DISTRICT COUNCIL
NORTH OXFORDSHIRE

23/00962/PREAPP

19th May 2023

Thank you for your pre-application enquiry received 11th April with regard to revised proposals at Windrush, Austin Road, Bodicote. You state: "The development looks to further the scheme from a previously approved planning application 20/01457/F. Guidance from the recent pre-app report 22/03658/PREAPP has been given careful consideration. The main concern regarding the bulk and mass of the extension has been addressed by raising the pitch of the existing bungalow by 8.5 degrees (790mm) and by reducing the ridge height of the annexe to match this. Flat roof dormers have been introduced to the north and south elevations to provide enough head height and make the rooms habitable. The internal layout for the proposed scheme has now been interlinked with the existing bungalow and works as one large detached dwelling."

South Elevation
1:100

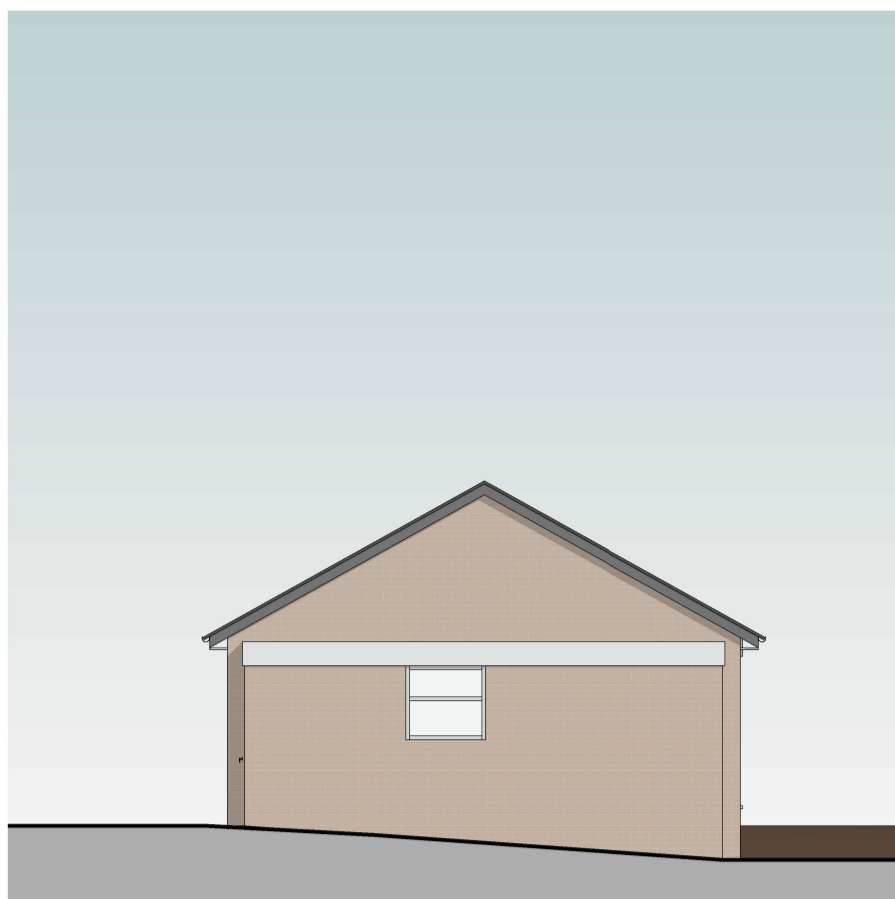
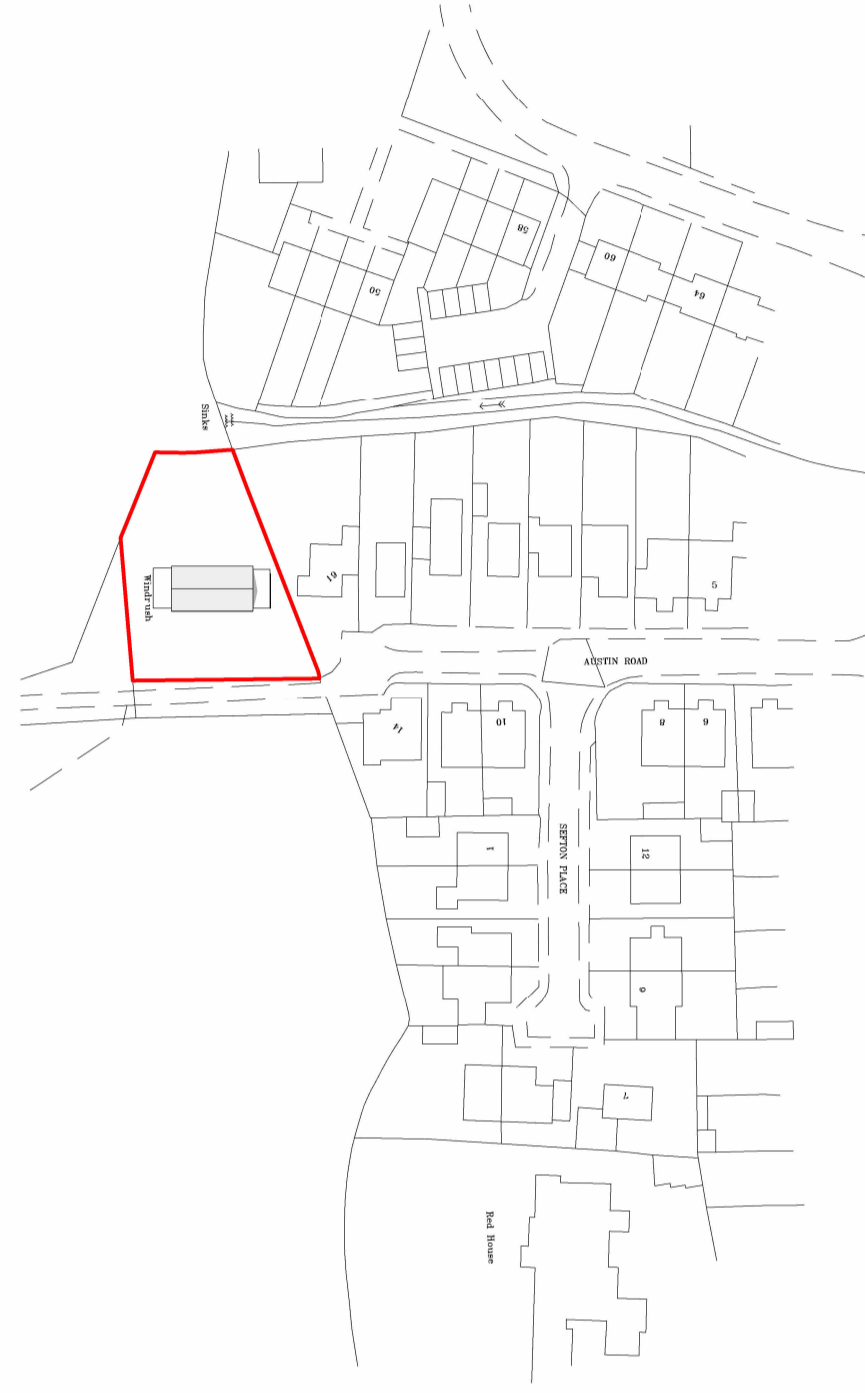
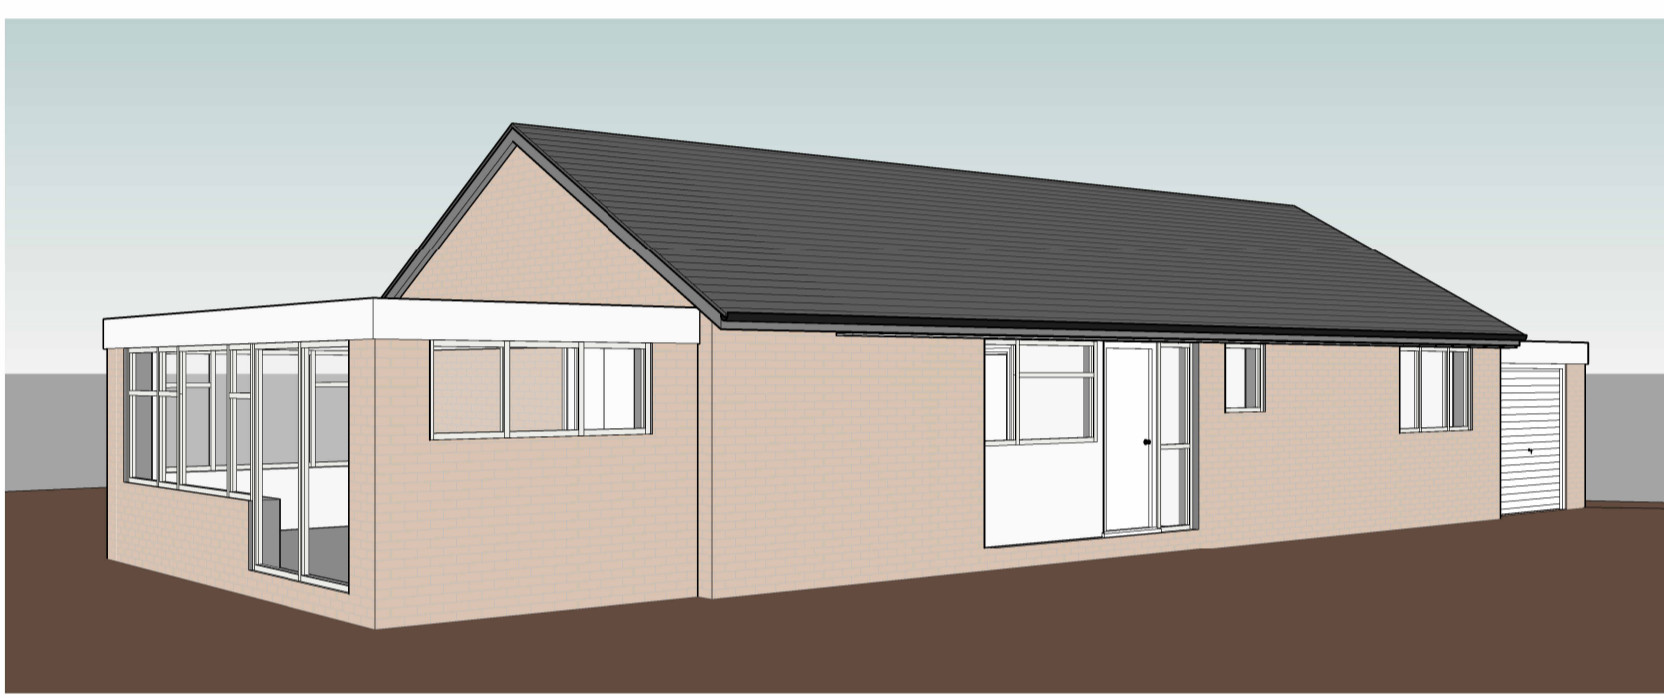
The proposal includes a two storey side and front extension to provide a garage and annex, to adjoin the side wall of the existing bungalow. I note the height has been reduced from the previous proposals by 1 metre, and dormers are now proposed on each side of the extension to enable the second storey. The extension would be sited in a similar place to the previously approved garage, 20/01457/F, although the approval was detached, single storey with a lower ridge and width than the proposal.

The proposed amended scheme would still result in an overly prominent development that would overwhelm the character of the existing dwelling. This is owing to the excessive projection of the extension and large dormers proposed to facilitate a second storey. The proposed two storey side and front extension would appear overly prominent in the street scene. The extension would not be a subservient addition; indeed, it would overwhelm the character of the original bungalow. Residential extensions should be proportionate to the host dwelling, and not overwhelm or detract from the character of the property.

The second storey for the bungalow is proposed to be facilitated by dormers along both roof planes. As previously mentioned, dormer windows are out of character with the surrounding area, which comprises bungalows and two storey properties. The proposed dormers are overly bulky and overwhelm the roof.

It is noted the render has been scaled back from the previous proposals, which is generally supported. However, the position of the render on this proposal contributes to the appearance of the separateness of the extension to the existing bungalow, as the main property would remain predominantly brick and the extensions rendered. Considering 3D View 1 provided on drawing number 007E, due to the material changes and front doors the proposal appears as two separate dwellings. As previously mentioned, the brick should be the overriding material, due to the existing dwelling.

While not raised within the previous pre-application enquiry, you should consider appropriate fenestrations to the front and rear of the smaller side extension (providing an en-suite and dressing area), as this would relate better to the dwelling. Further, there is opportunity for a better roof design that assimilates with the bungalow. While it is noted there is a previous approval for this element, the approved scheme incorporated a door to serve the storage area, which was in character with the extension. This is a minor suggestion for improvement, should an application be submitted.

If not redeveloping the bungalow as per our comments above, we would advise that the previously approved garage would be the maximum bulk and massing achieved in that position, due to the relation with the main bungalow and the impact on the visual amenity of the surrounding area.
